Prior Notification for Permitted Development

Schedule 2 Part 1 Class AA

Development: Prior approval under Schedule 2, Part 1, Class AA for the removal of existing roof, construction of new walls above existing walls to form new first floor walls and erection of new roof with a maximum height of 10.35m.

Location: The Haystack Sea Lane Ferring BN12 5EP

GROUND FLOOR PLAN | PROPOSED

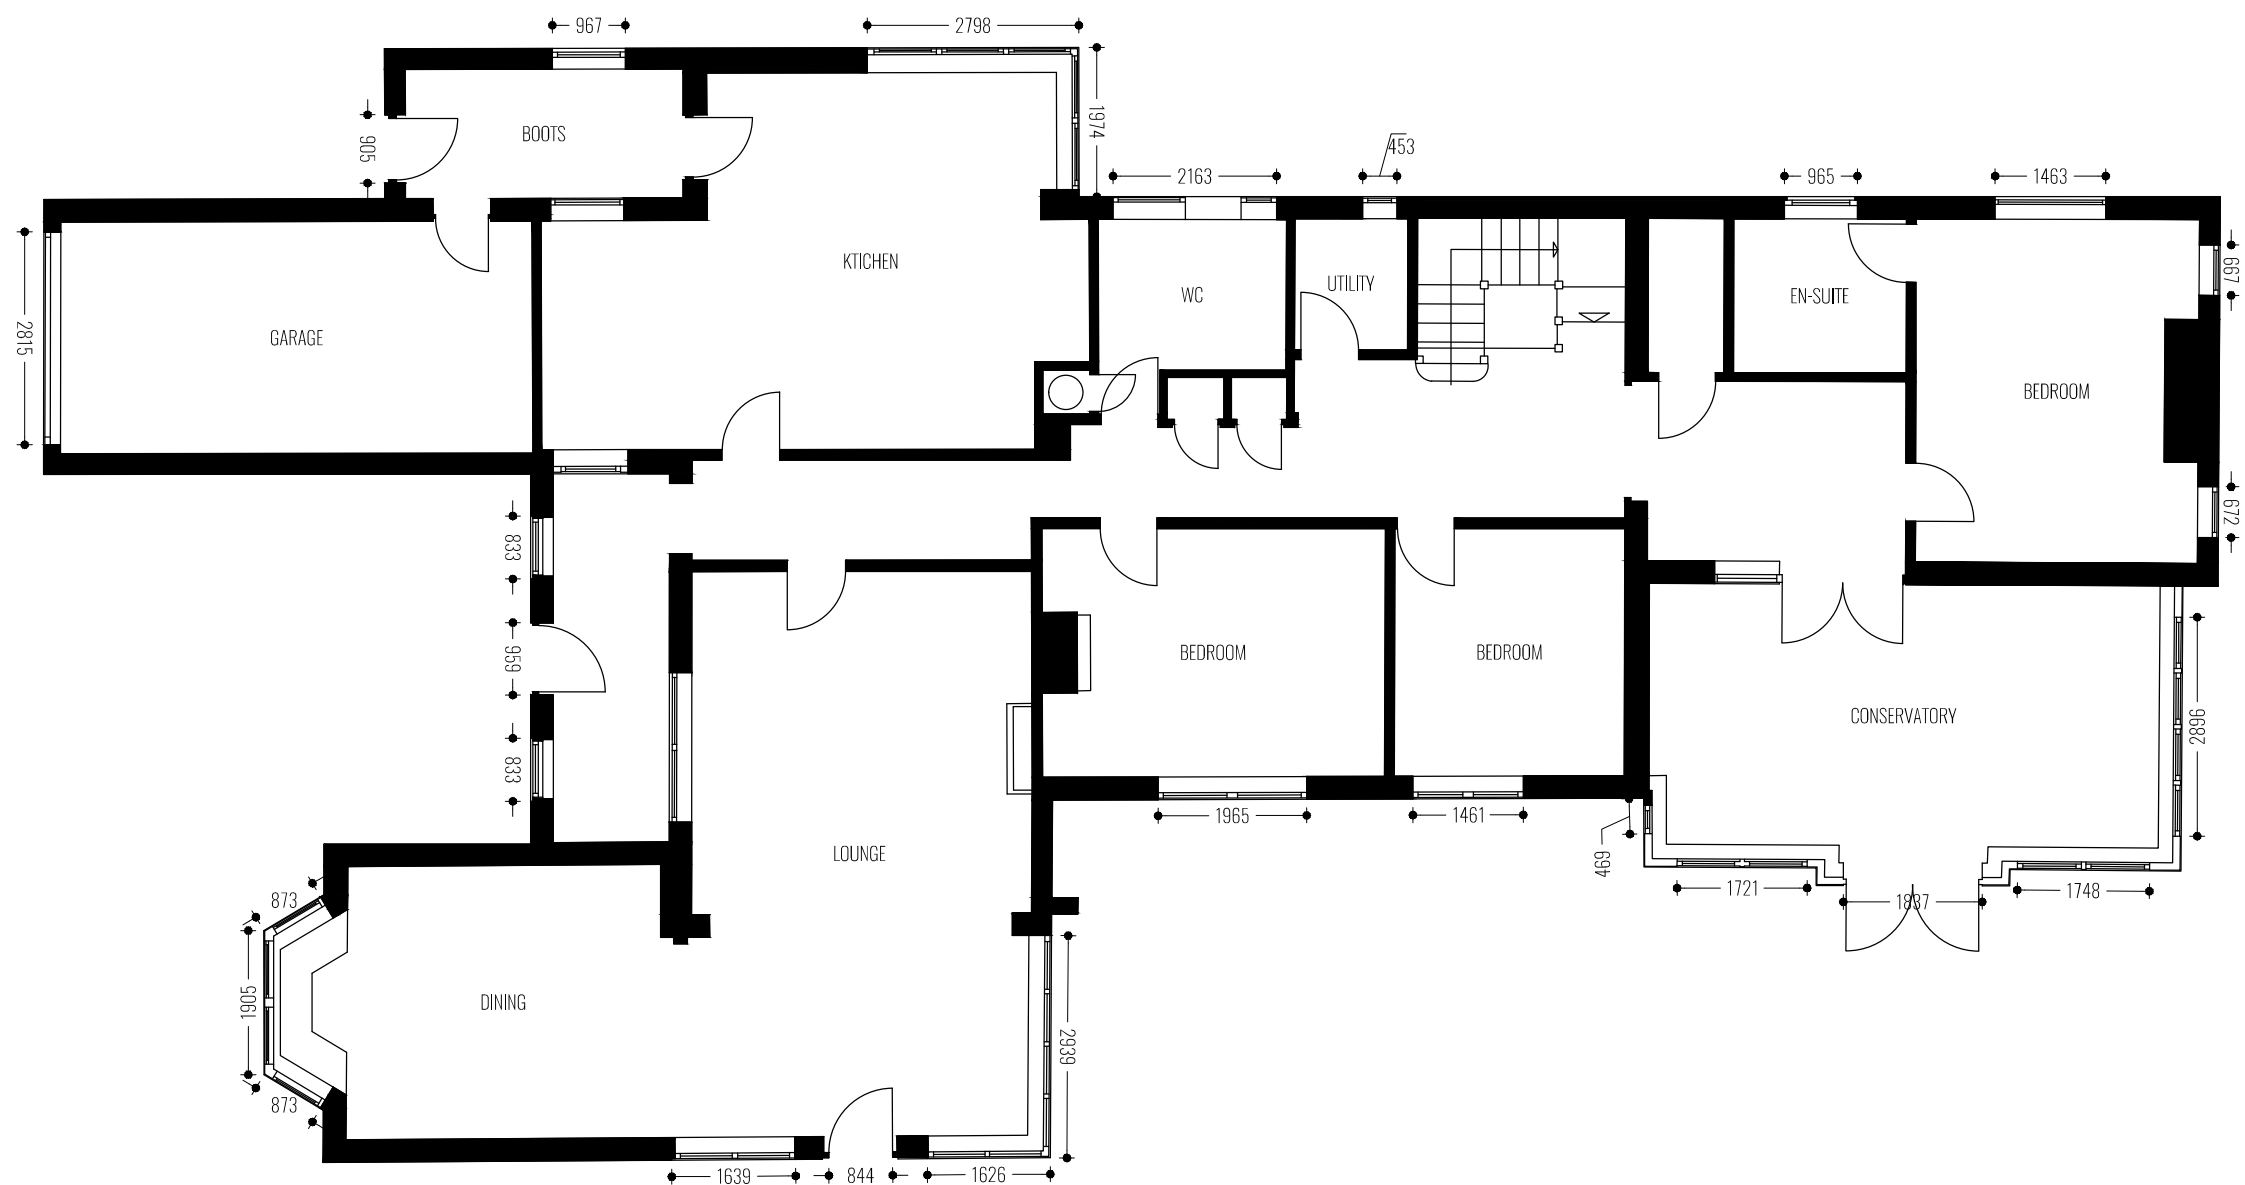
Please provide dimensions of the windows on the proposed floor plans or elevations.
